**Our Case Number:** ABP-317560-23

**Re:** Proposed windfarm development including 13 no. wind turbines in Bunnyconnellan, Co. Mayo and hydrogen plant in Castleconnor, Co. Sligo.  
Carrowleagh, Bunnyconnellan, Co. Mayo and Curraun, Castleconnor, Co. Sligo.

**Response to Third Party Submission Document Made by  
Mercury Renewables to An Bord Pleanála Dated November 2023  
with Regard to Application No; ABP-317560-23 (PA16.317560)  
and Observations of Submissions to said Application by Other  
Third-Party Applicants.**

Figure 15.13: Junction Turning Movements at N59 / L-6612-1 – AM Period

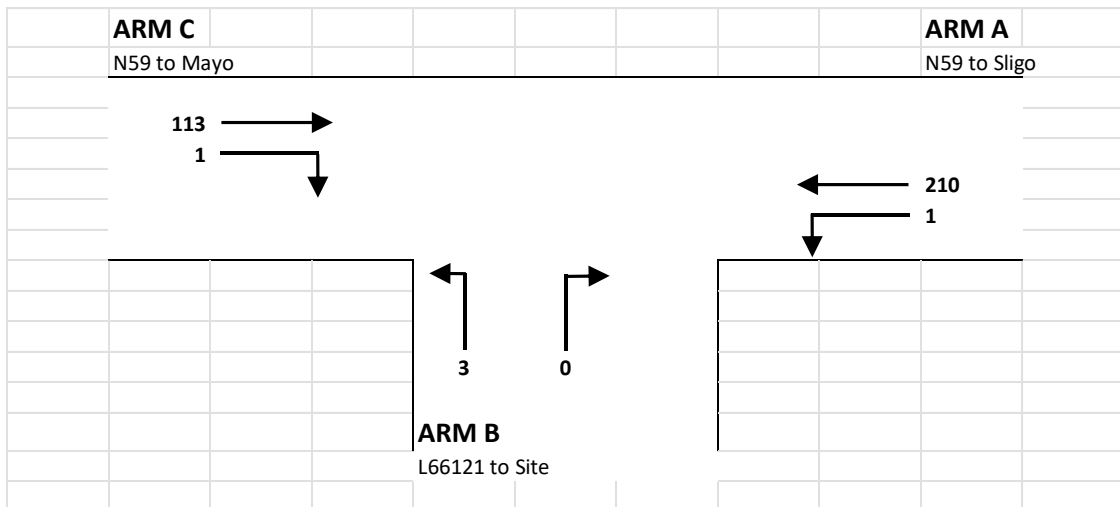
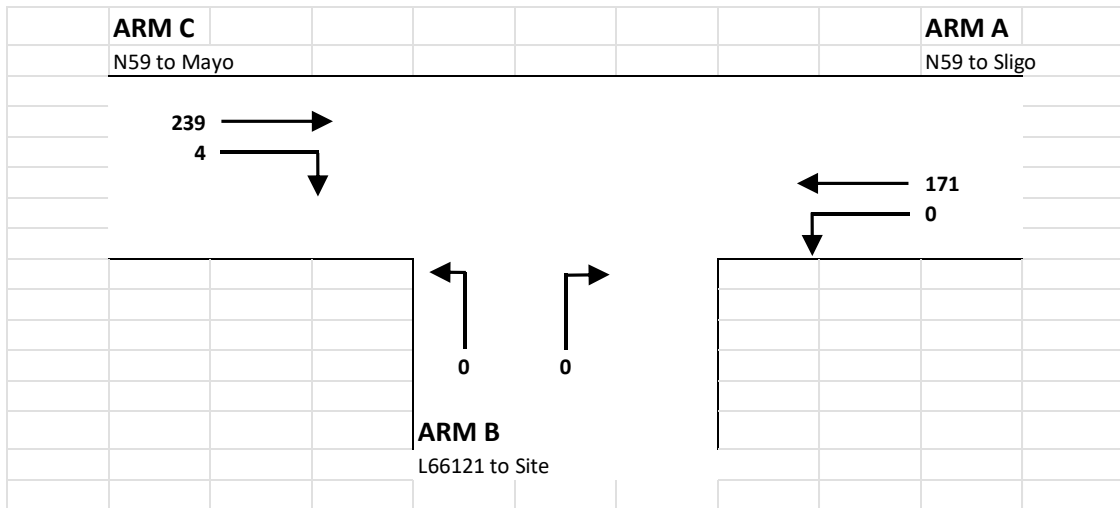
This will increase the risk of accidents with HGV's, especially during dark rainy winter months. It also invalidates the assumptions made in relation to the ability of this junction to manage this type of traffic flow. The intersection from the site onto the smaller local road L-66121 is not considered. See below.

#### **Concerns from Local residents over N59/L-6611 / N59/L-66121 staggered junction.**

Janice and Wes Moran, local residents of the area (Eircode F26A584) submitted observations with respect to the staggered junction where the proposed round about is to be placed. They cite this location has been on a hill with existing line of sight issues. There are also hollows where vehicles disappear out of sight completely. This submission is in line with other observations with regard to this junction. There have been a number of accidents at this location in which local people have been involved in trying to turn off the N59. Also comment on the added danger in this area at nighttime due to the topography which gives rise to the site issues and the dips and hollows in the road. As mentioned previously gas tanker traffic, HGVs, will be at its height during the winter months when visibility is affected by low light levels and inclement weather.

I note that according to Transport Infrastructure Irelands (TII) submission on the proposed development, no design plan has been submitted for the N59/L-66121 junction which is a

TII has no record that a Design Report has been submitted in relation to the proposed alterations to the N59 Junction with the L66121. TII Acceptance of a Design Report is required as set out in TII Publication GN\_GEO\_03030 ([www.tiipublications.ie](http://www.tiipublications.ie)). TII considers that this matter should be resolved in advance of any decision on the
